# CITY OF ALBUQUERQUE

April 19, 2017

RE: **Garcia Honda Gen 3 Service Bldg**  
**8301 Lomas NE**  
**Request for Certificate of Occupancy – Permanent**  
**Hydrology Final Inspection - Disapproved**  
**Engineer's Stamp Date 8/29/18 (J19D072)**  
**Certification Dated: 4/12/18**

Mark	Date	Description
	05/05/17	
Project Number	15918	
Drawn By	JJB	
Checked By	VAN H. GILBERT ARCHITECT	
Copyright ©	AS-BUILT	
SHEET TITLE	GRADING, DRAINAGE & UTILITY SERVICE PLAN	
	C-101

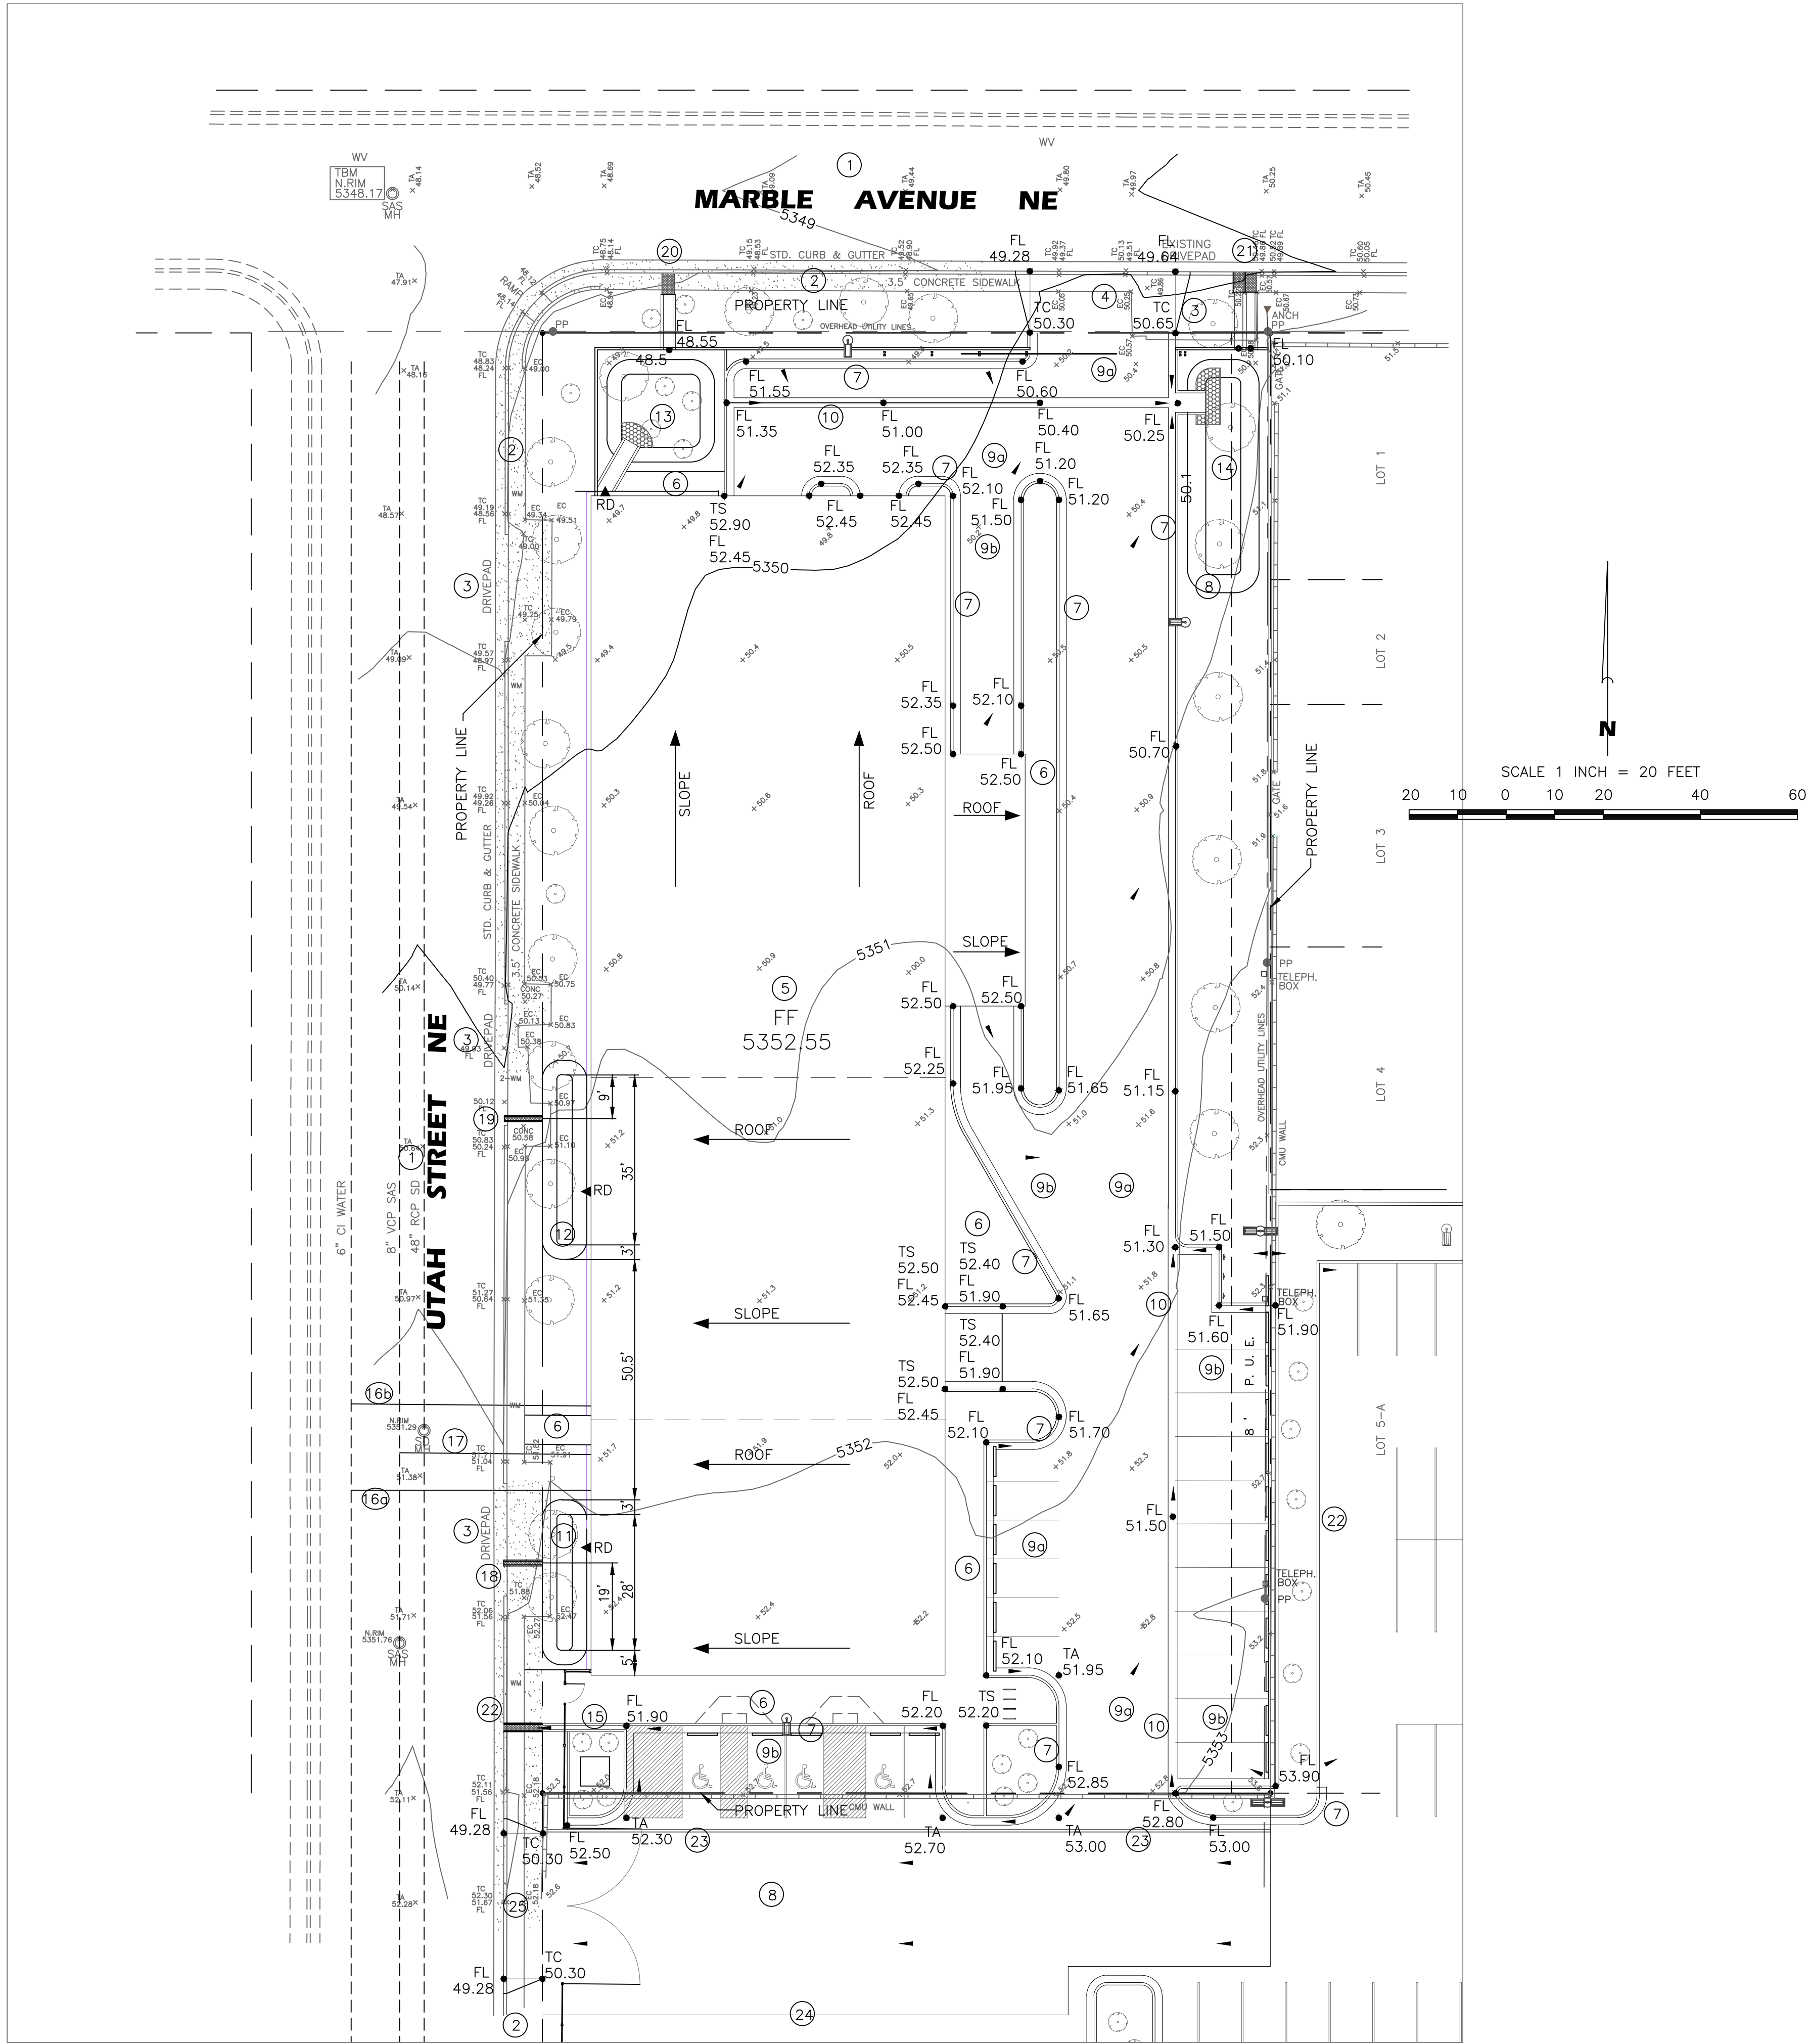
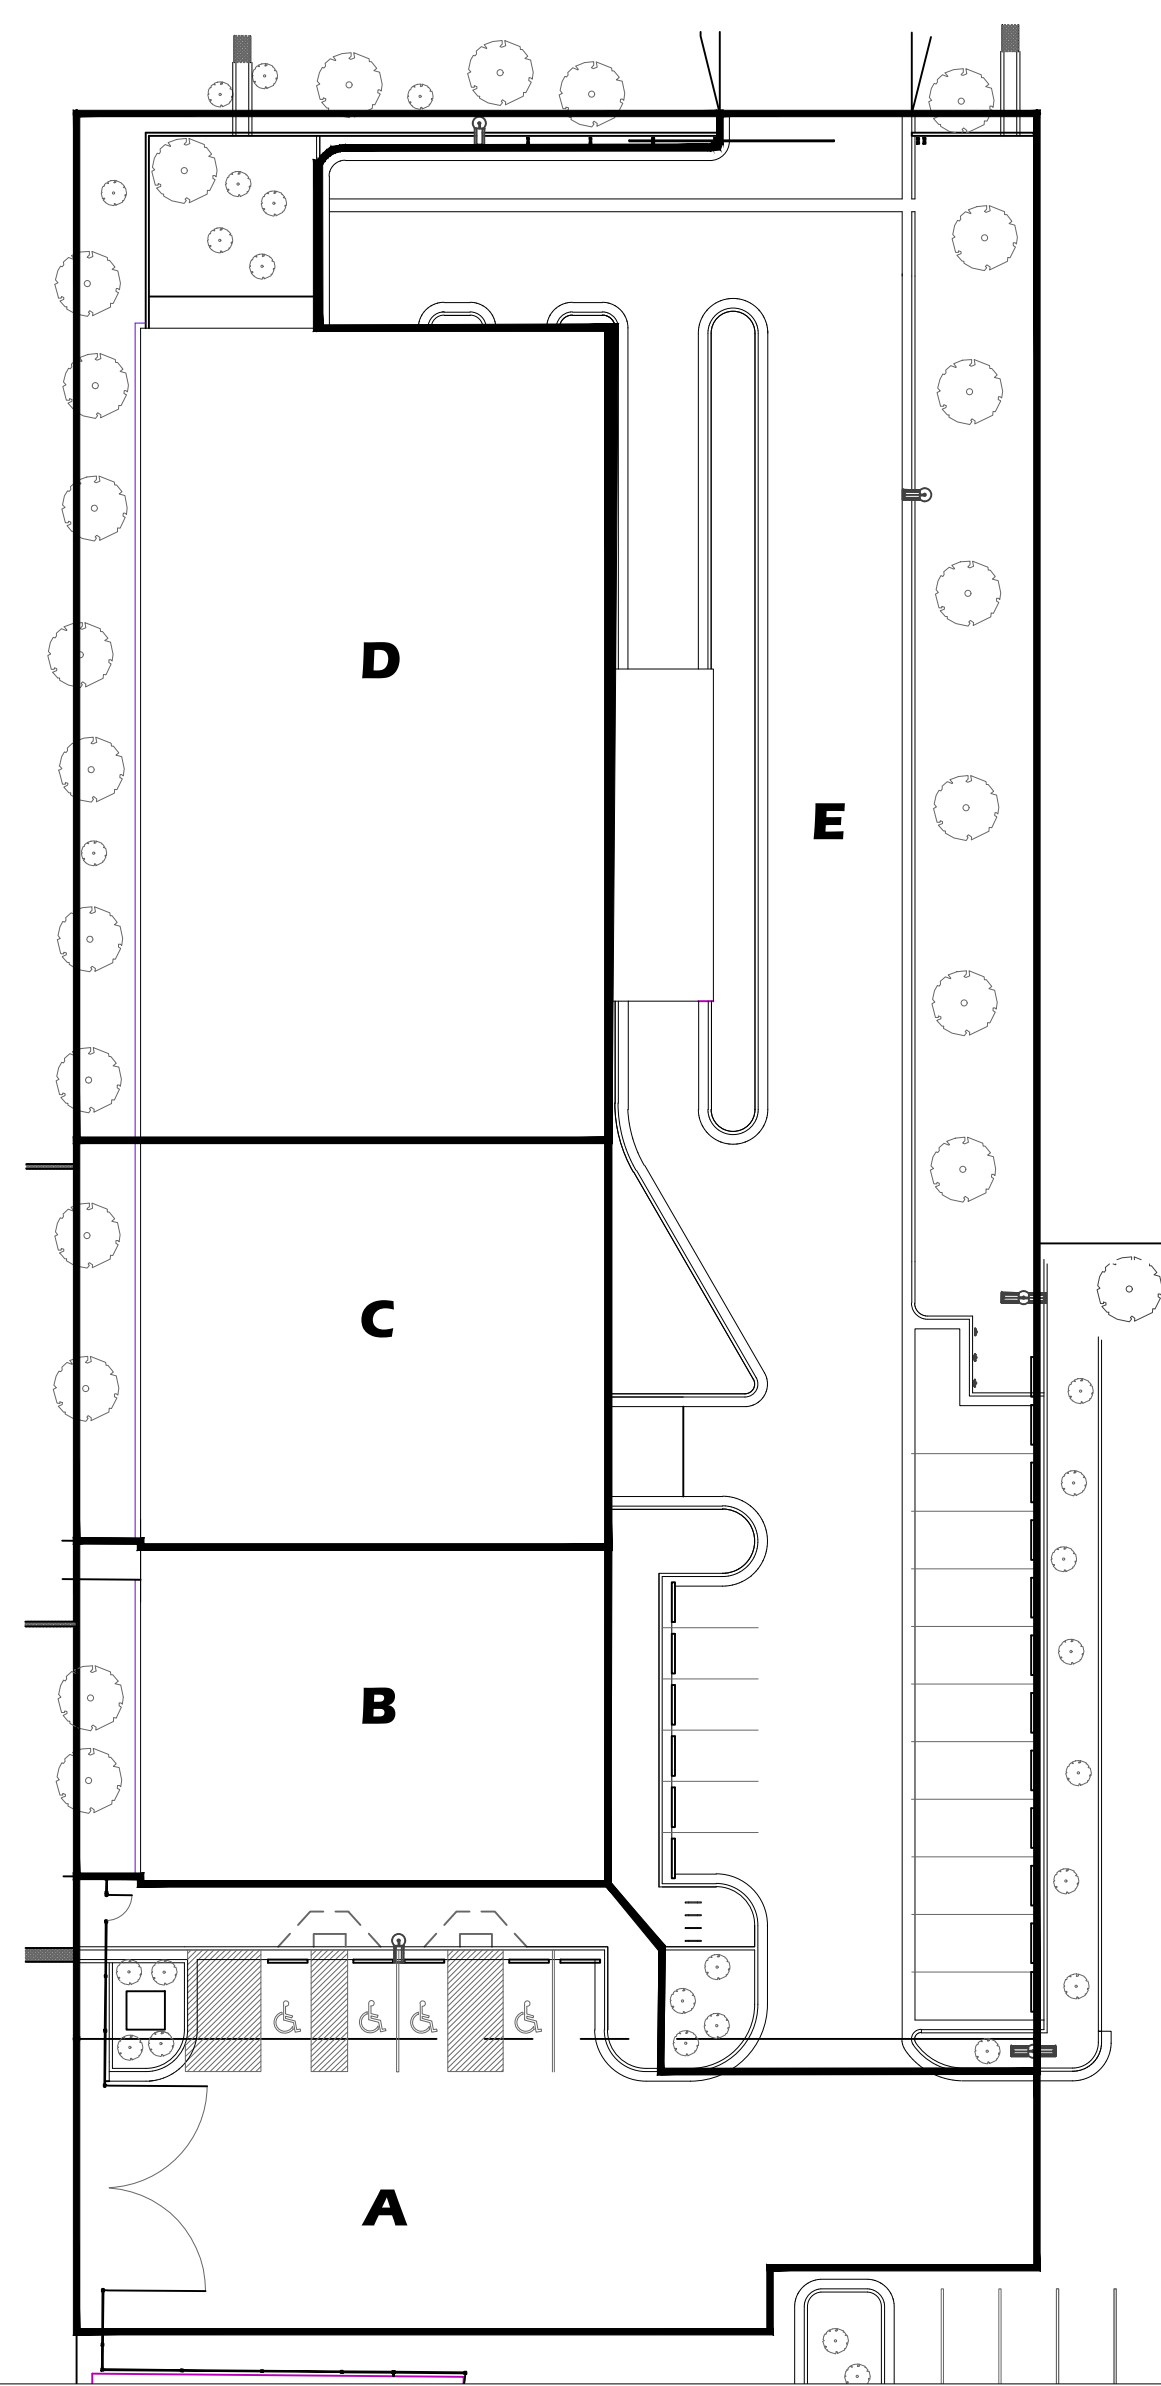
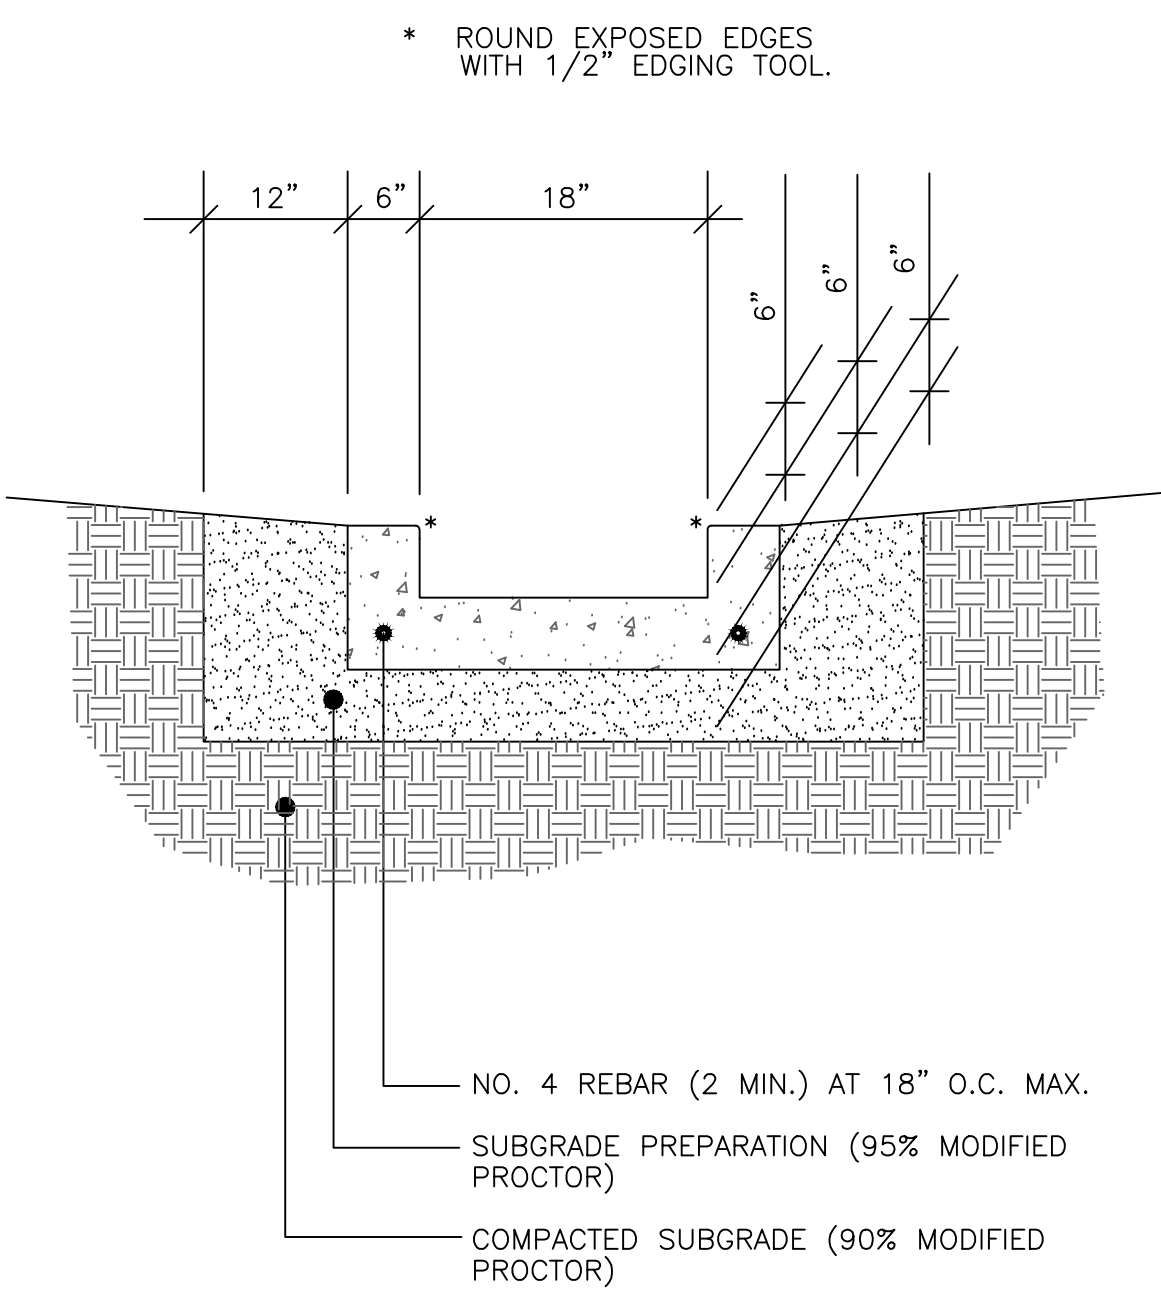
1. The Drainage Certification language, per DPM Ch. 22, Section 7, is missing.
2. The sidewalk culverts need to be built to city standards, refer to Standard Drawing 2236 for correct construction:
  - a. The smooth rod, welded to the front of the steel plat and free of burrs and sharp edges was missing from all culverts.
  - b. All screws need to be tack welded or ground down to discourage removal and theft.
  - c. The sidewalk culvert described in keyed note 19 has several screws that were not countersunk and are left projecting above the plate.
  - d. The sidewalk culvert described in keyed note 20 is not flush with the sidewalk, creating a trip hazard.
  - e. The sidewalk described by keyed note 21, needs to be removed and rebuilt as two culverts as stated in the approved grading plan. Per drawing 2236, single culverts shall not exceed 24" wide.
